RMG Response Letter to—Development Plan and Final Plat for Northcrest Flex Space PPR

PCD File No.: PPR-21-036

Fourth Review Letter

Subject: Northcrest Flex Space
2510 and 2522 Canada Drive
Colorado Springs, CO 80922

ENG:	DWG	
DRAWN:	TPT	
CHECKED:	DGW	
DATE:	08/12/2022	
#	REVISION	DATE
JOB NO.:	180649	
SHEET NO.:	C-02	
	of 12

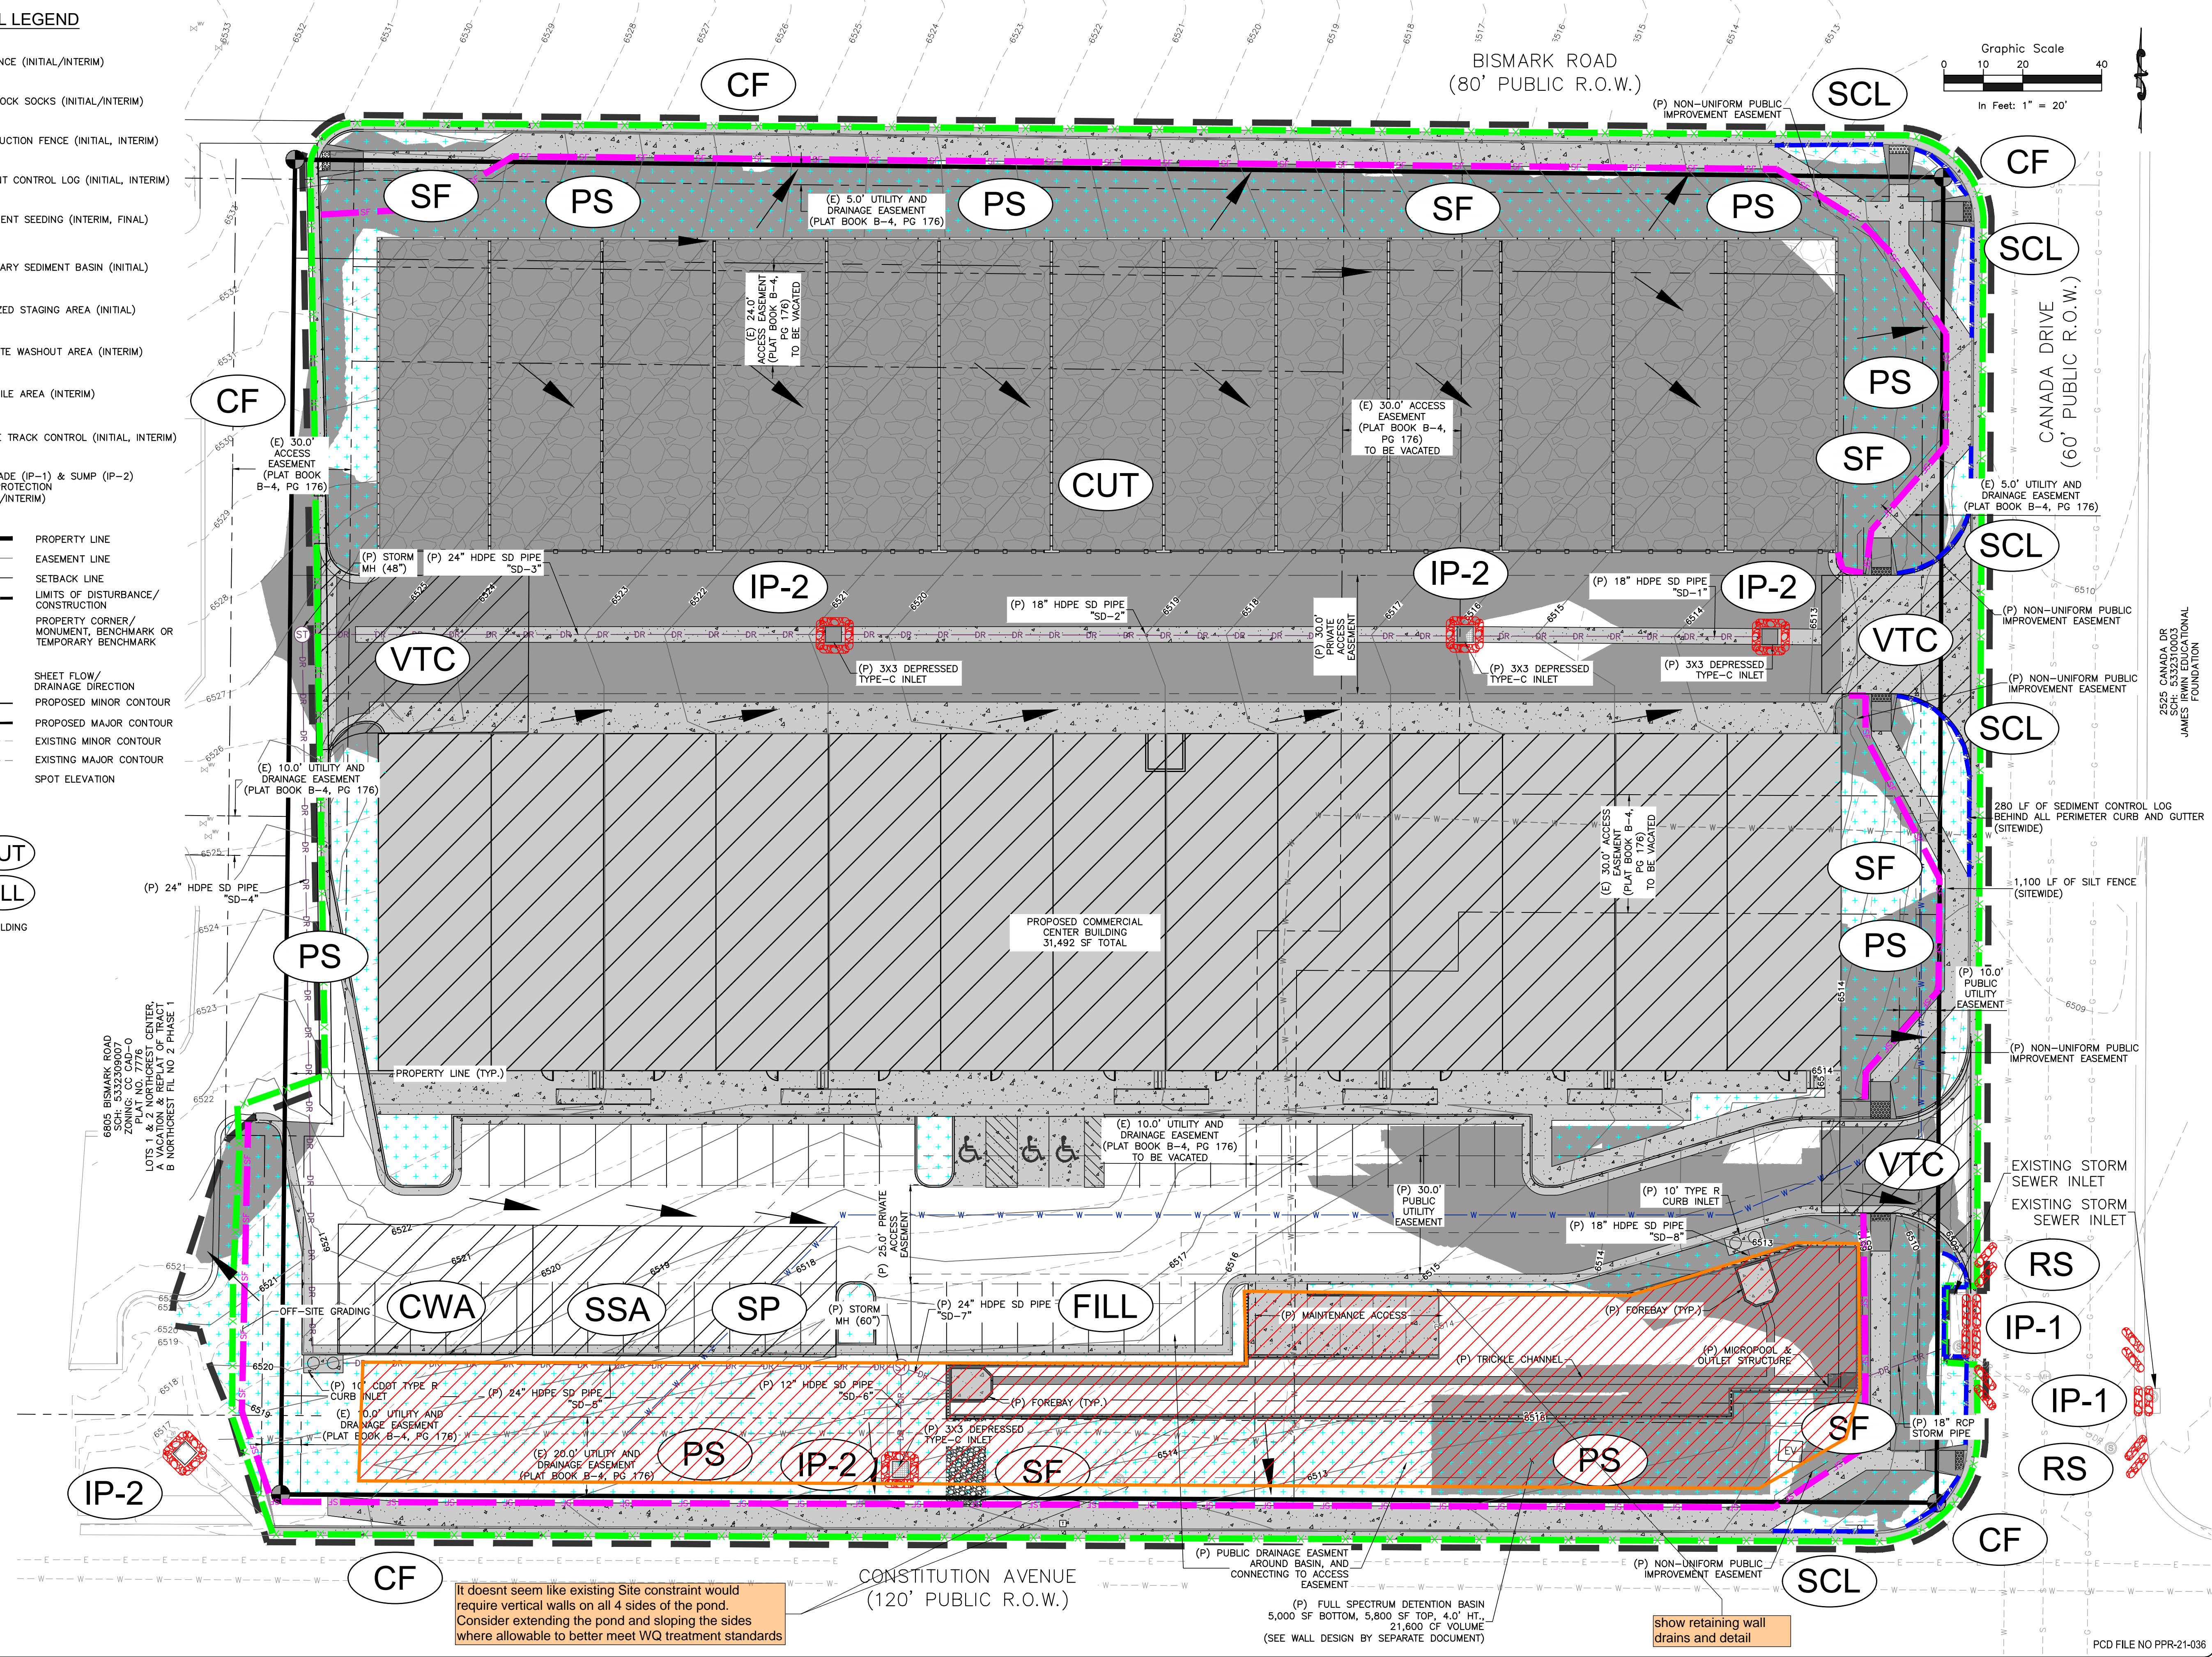
11. Update the erosion control legend per the markups.
RMG: The legend has been updated.
12. Show ditch contours and how it ties in with existing grade. or show a typical ditch section detail. unresolved.
RMG: The proposed ditch contours are shown tying into existing contours and a typical ditch section has been provided.

ENG:	DOV	
DRAWN:	TPT	
CHECKED:	DOV	
DATE:	08/12/2022	
#	REVISION	DATE
JOB NO.:	180649	
SHEET NO.:	C-03	
	of 12

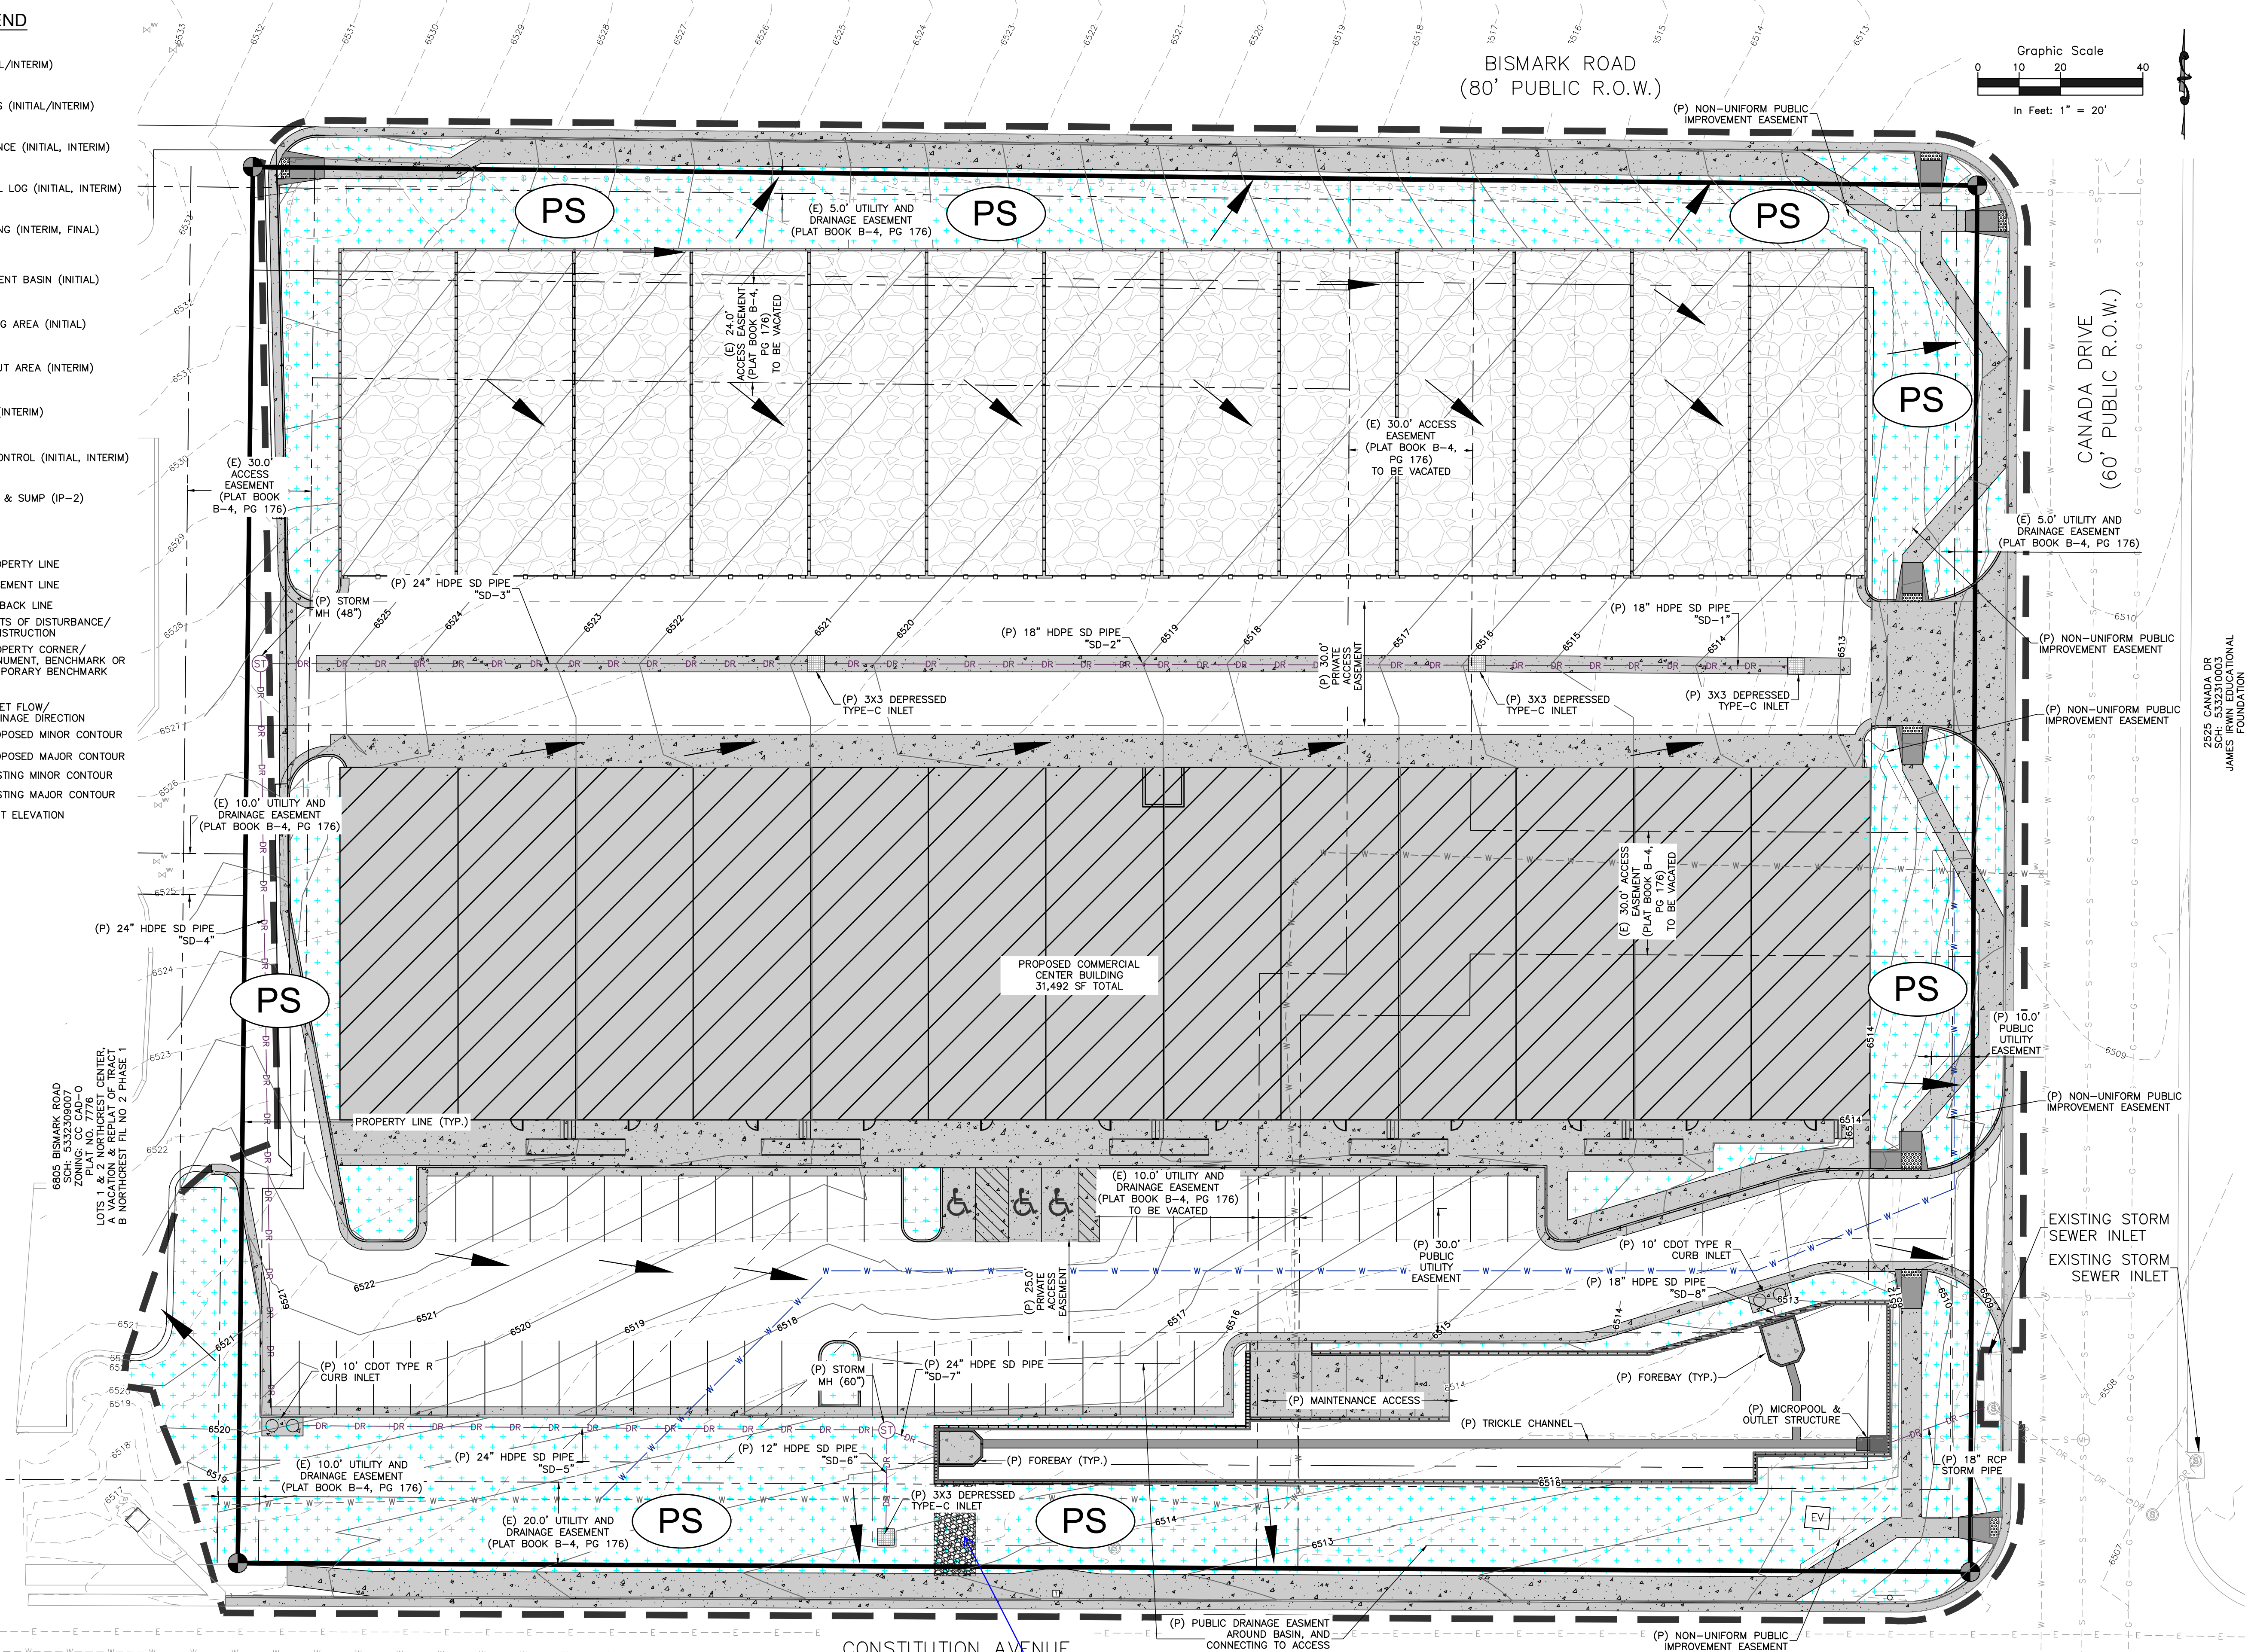
13. Removing this inlet significantly increases the area of flow that will not be treated by the EDB. See drainage report for additional comments.
RMG: This inlet has been added back to capture the flow from this area.
